### H18-0879-25 - Land adjacent 39 Custom House Street

**From:** Hill, Grace <Grace.Hill@e-lindsey.gov.uk>  
**Sent:** 15 October 2025 10:45  
**To:** Niland, Mark <Mark.Niland@sholland.gov.uk>  
**Cc:** De-Ruyck, Chris (ELDC) <Chris.De-Ruyck@e-lindsey.gov.uk>  
**Subject:** H18-0879-25 ecology comments

Erection of 8 dwellings

Post-Development Plan
Post-Development Map

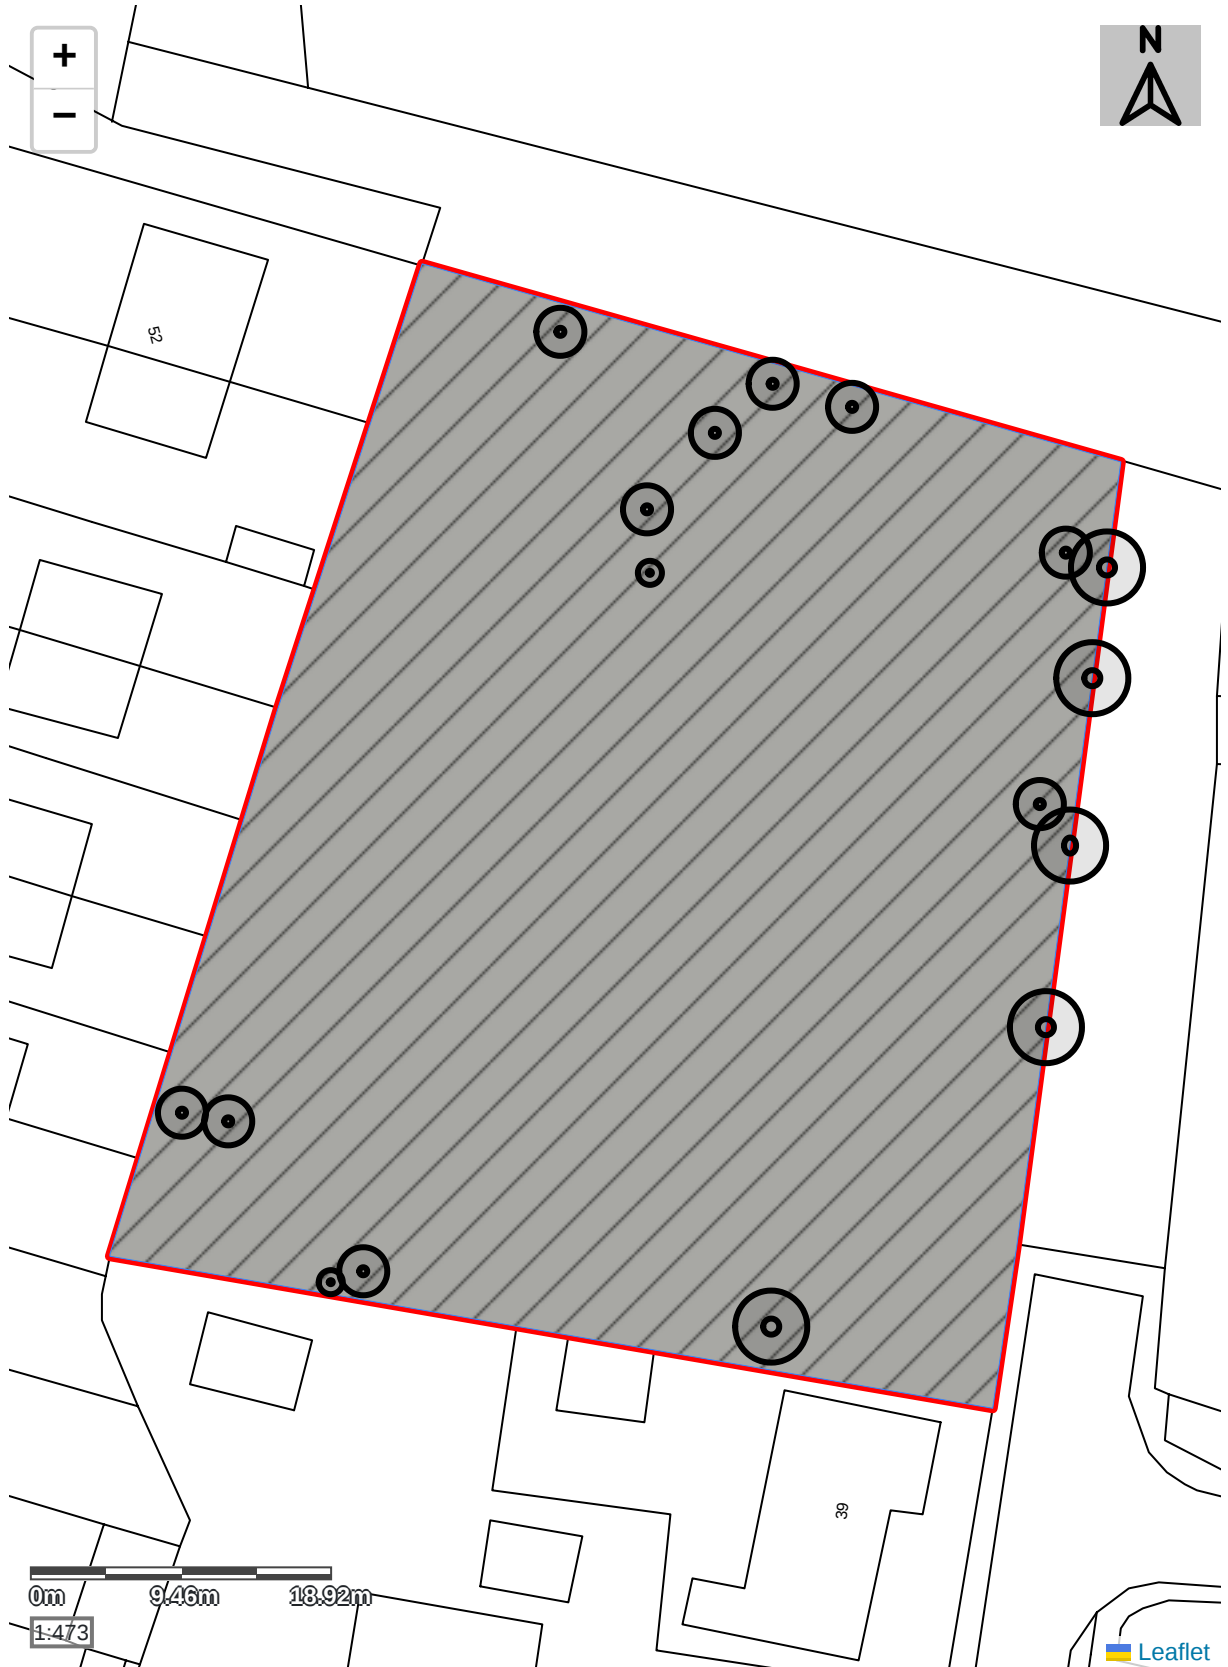
- It is not evident where any ruderal ephemeral will be 'retained' or 'enhanced' in the post development plans and with them being such tiny sections of habitat I would be cautious as to accept that they could be either retained or enhanced in any capacity given the scale of works to be completed onsite. Therefore, we request that all ruderal ephemeral land is lost and the habitat parcels that were previously retained or enhanced be altered to an alternative created habitat e.g. developed land/ sealed surface.

- We also believe that the proposed modified grassland creation should have a target habitat condition of moderate condition rather than good condition due to a potentially high area of grass covered by tree canopy and increased urban pressures in the area (such as increased foot fall, cat and dog fouling etc...)
